# CITY OF ALBUQUERQUE

January 18, 2017

**RE: Lot 38 Block 8 Unit 22 Volcano Cliffs Subd.  
6435 Picardia Pl NW  
Request for Permanent C.O. - Not Accepted  
Engineers Stamp Date 5/18/16 (D10D003E38)  
Certification Dated: 1/15/17**

GRADING AND DRAINAGE PLAN
LOT 38 , BLOCK 8 , UNIT 22 , VCS
ADDRESS: 6435 Picardia, PL NW

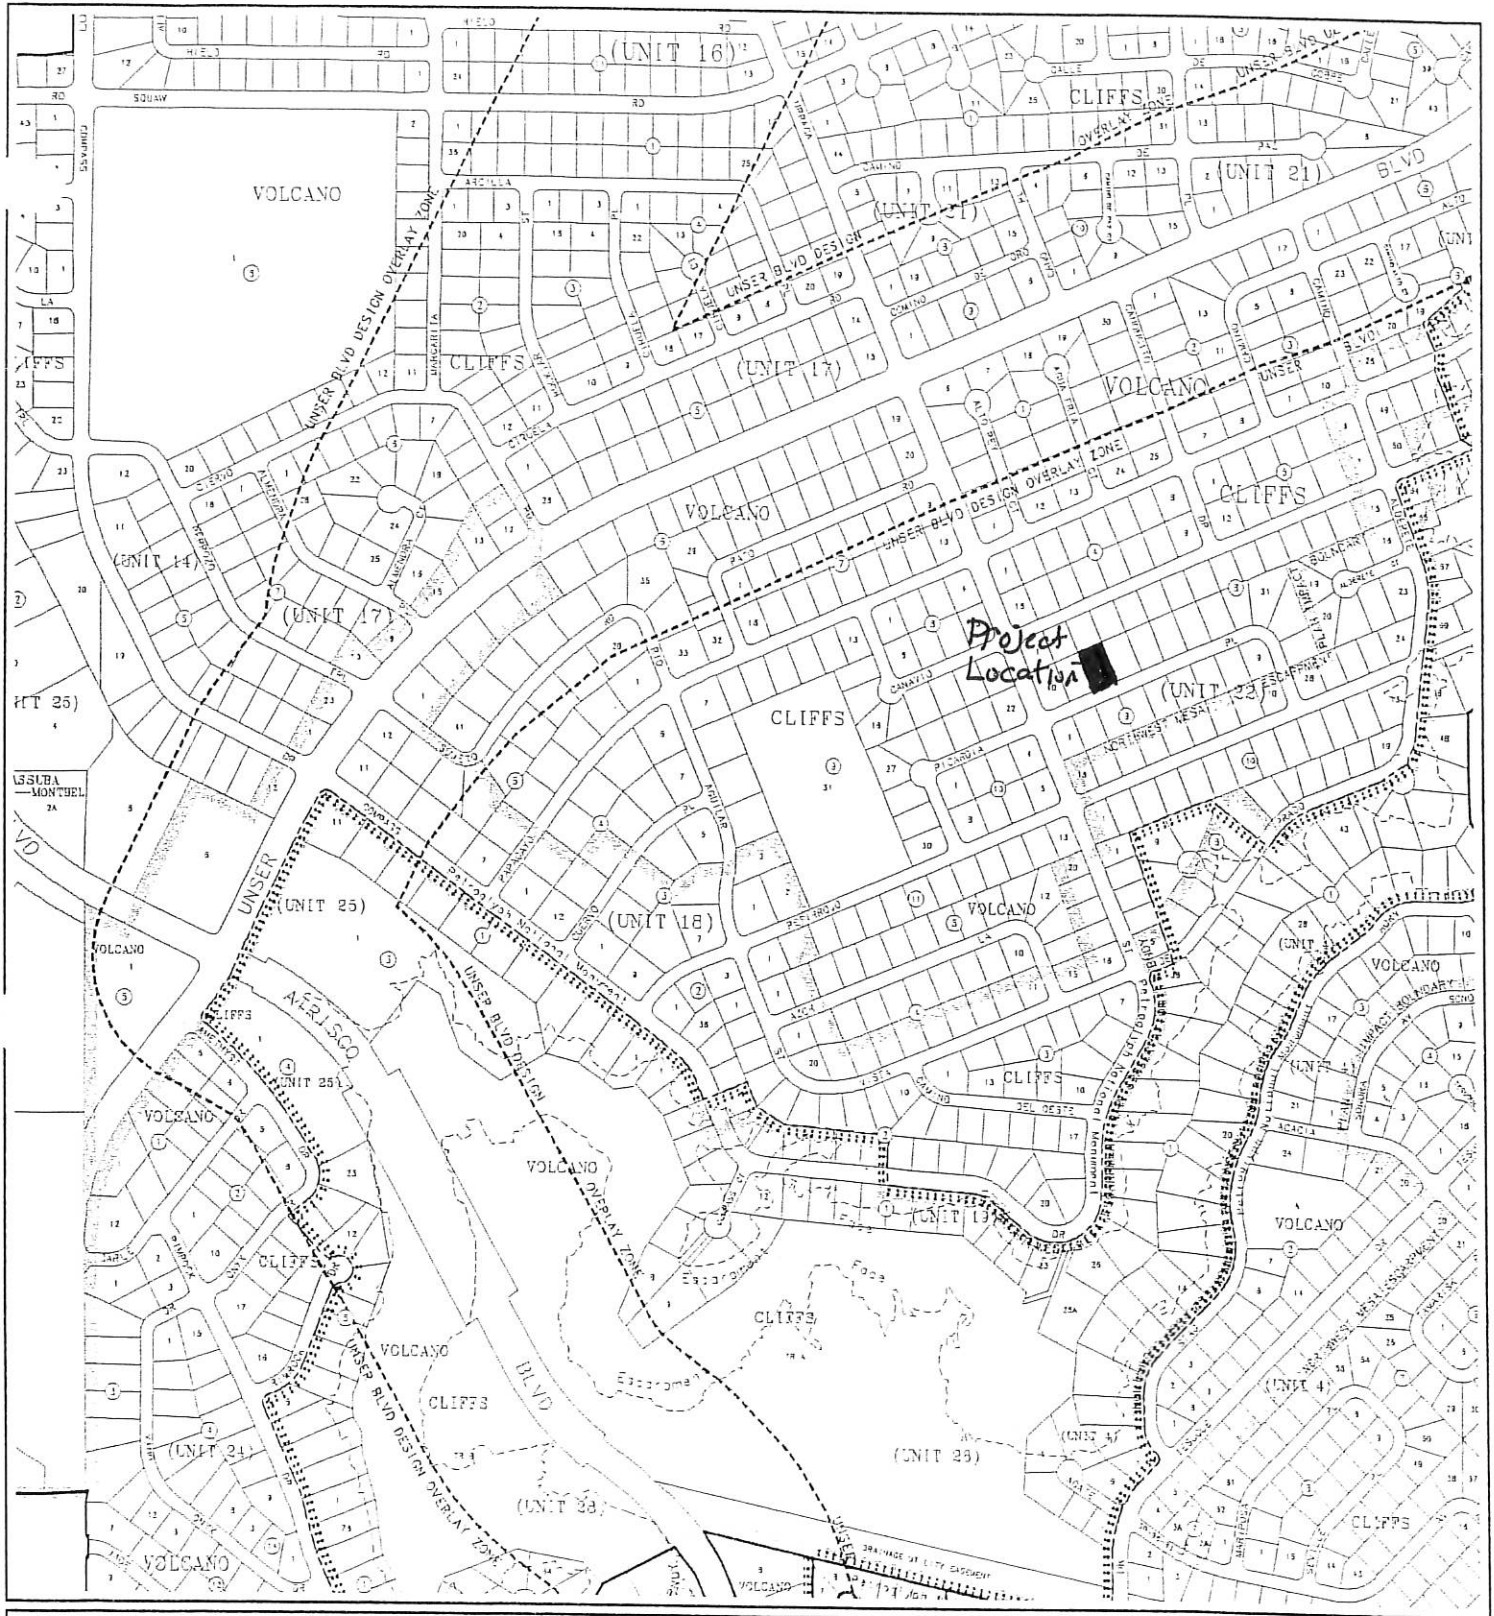
- The 8" x 12" opening in the backyard wall on the south side is missing. It must be added as indicated on the approved grading and drainage plan.
